City of Albuquerque

RE: DRAINAGE PLAN FOR SECOND PRESBYTERIAN CHURCH ADDITION
(J-14/D84) DATED JULY 20, 1989 & RECEIVED JULY 27, 1989

The following are recommended plan modifications and/or inclusions.

GRADING AND DRAINAGE PLAN
ADDITION TO 2ND PRESBYTERIAN CHURCH
808 EDITH BLVD. N.E.

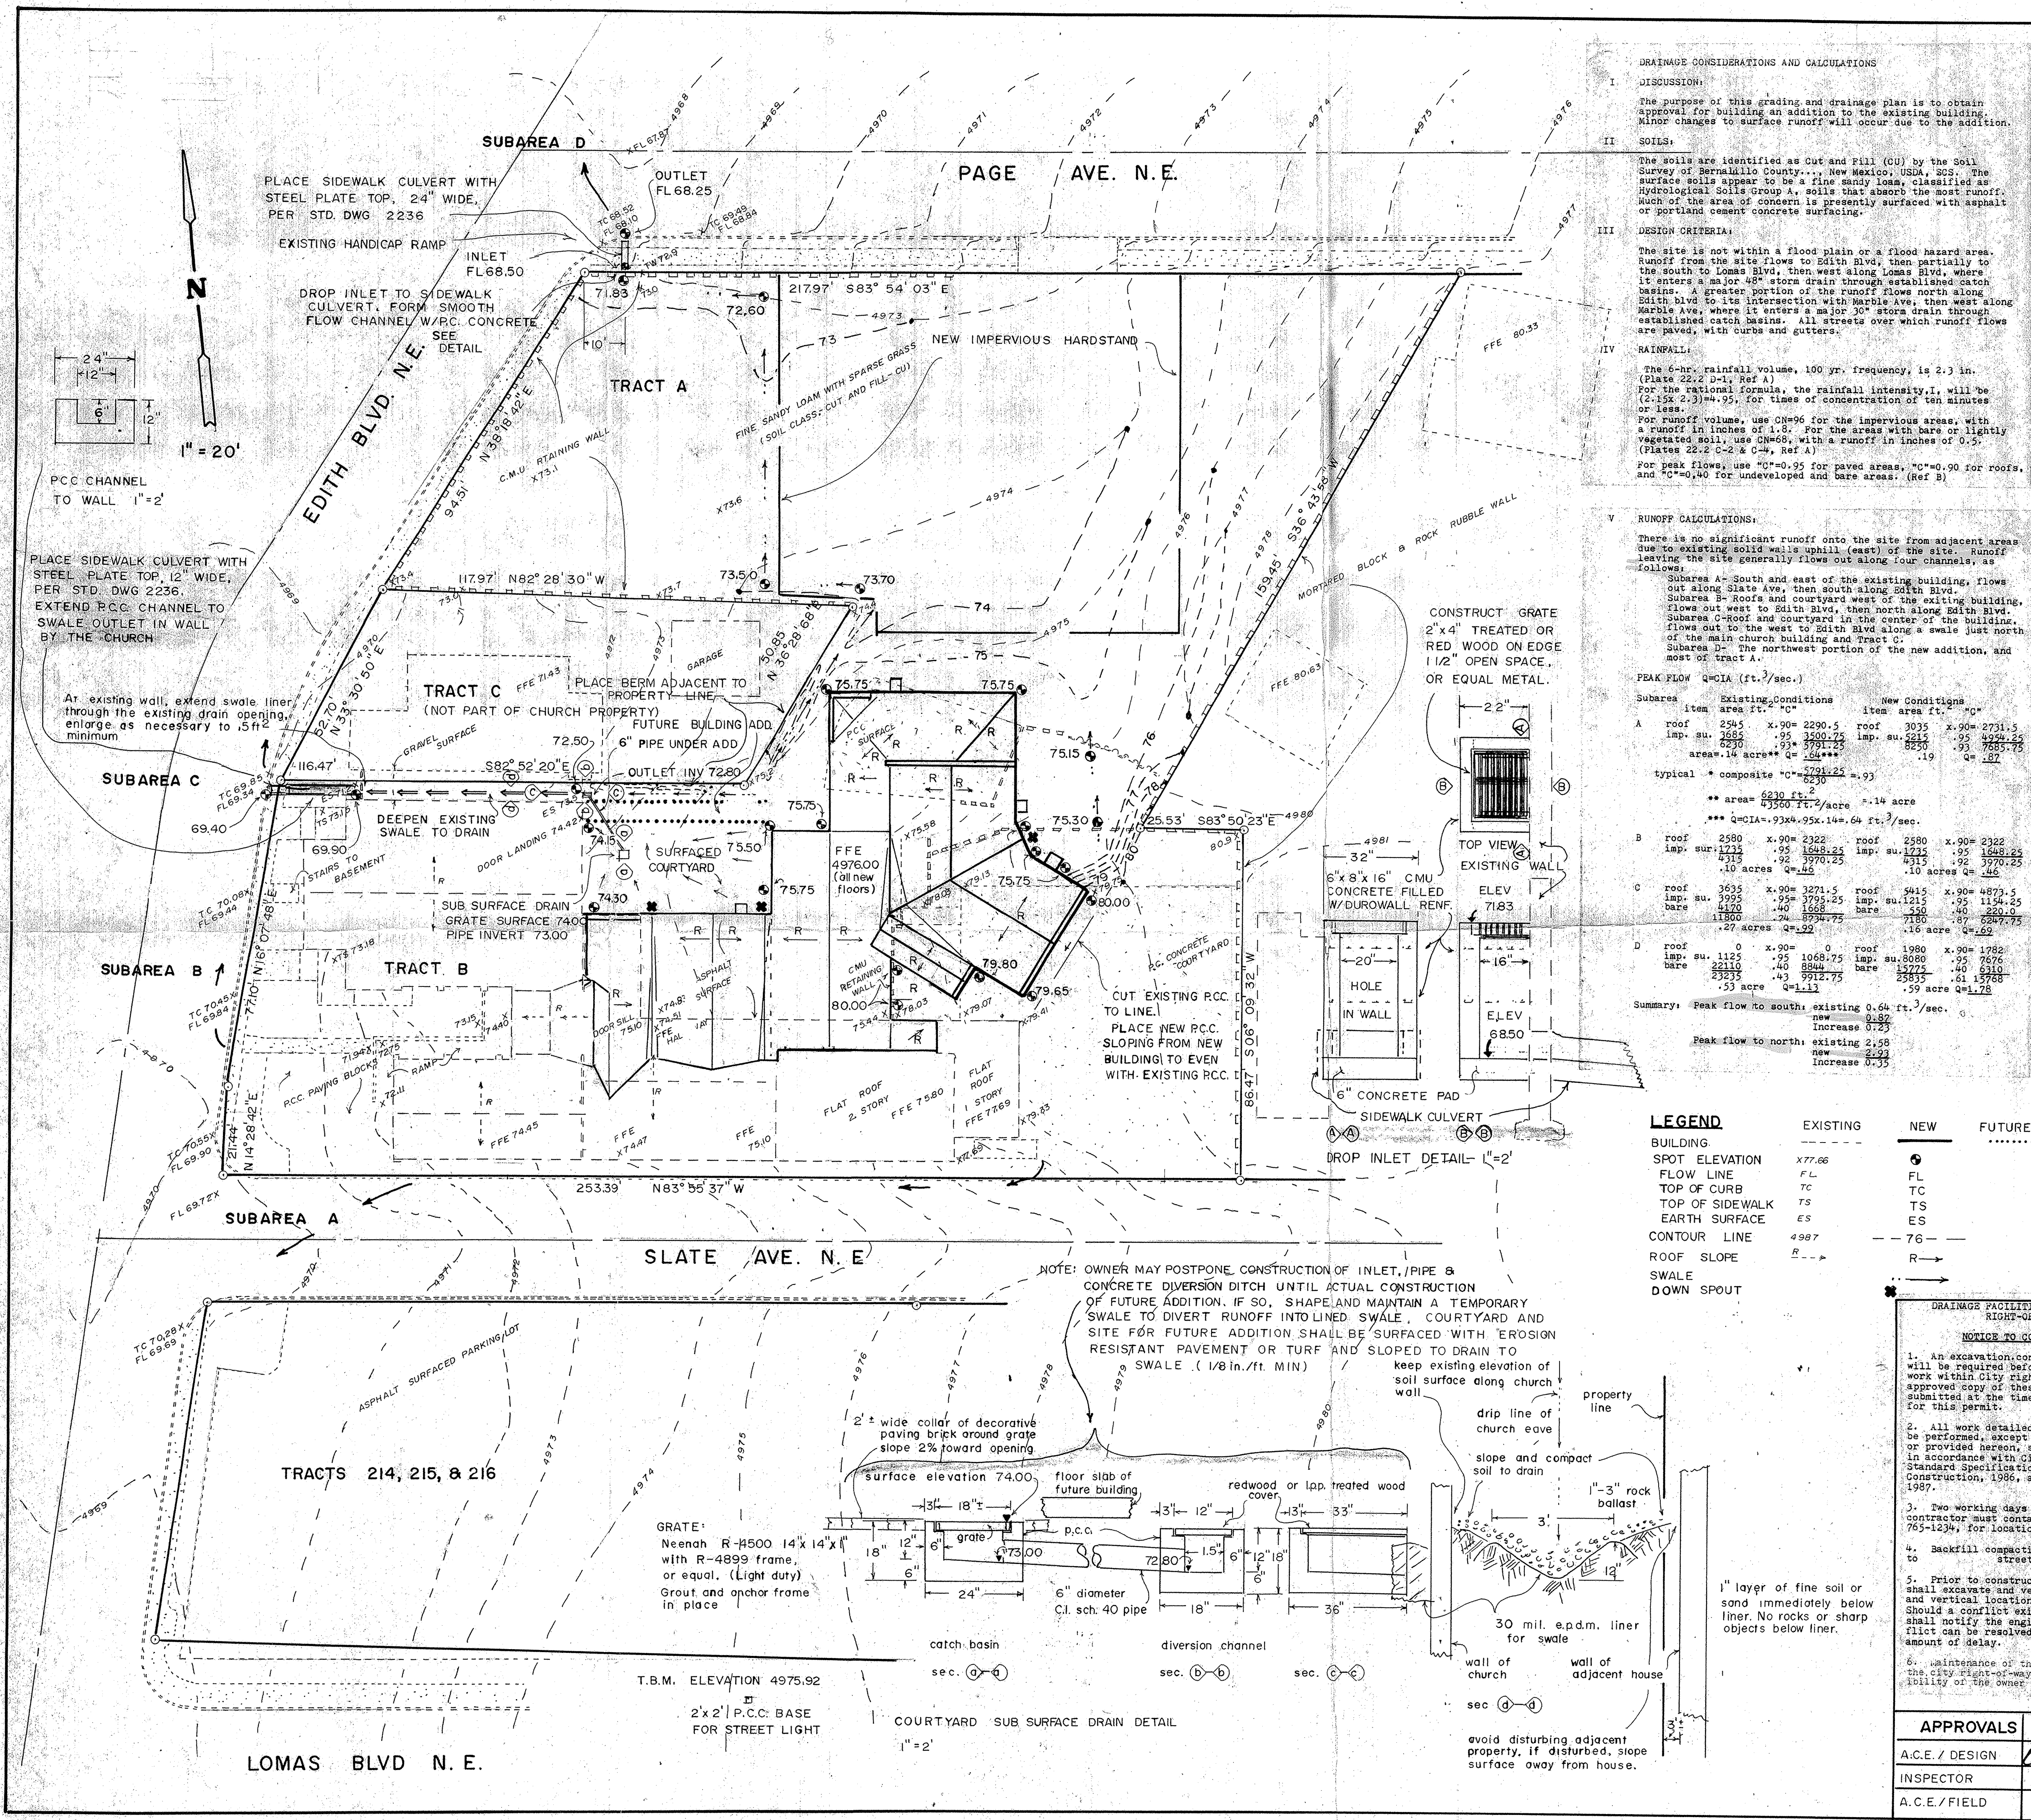
1. The PCC channel from the 12" sidewalk culvert to the existing wall opening must have the same capacity as the sidewalk culvert. (i.e., a 12" wide by 6" deep rectangular section.) Additionally, please provide documentation of the capacity of the PCC channel to the sidewalk culvert and the capacity of wall opening.
2. The wall notch detail for discharge to the 24" sidewalk culvert is not satisfactory. See attached detail, suggested.
3. The vinyl liner swale is okay. Cover rock to be 3" minimum layer of 2" round rock. Provide openings in existing walls at the discharge end of the channel to pass the maximum anticipated flow. (12" x 6" total opening area.) Slope lined swale should be a 1% minimum. Swale liner to be PVC, 30 mil, or equivalent.
4. Remove the option note on plan regarding the pipe construction. Construction of this pipe is required with this development.

5. Given the complexity of this development and the underground proposed construction, Certification will be required for Certificate of Occupancy release by this office.
6. The plan should include the S.O. #19 detail for the proposed sidewalk construction in the City right-of-way.
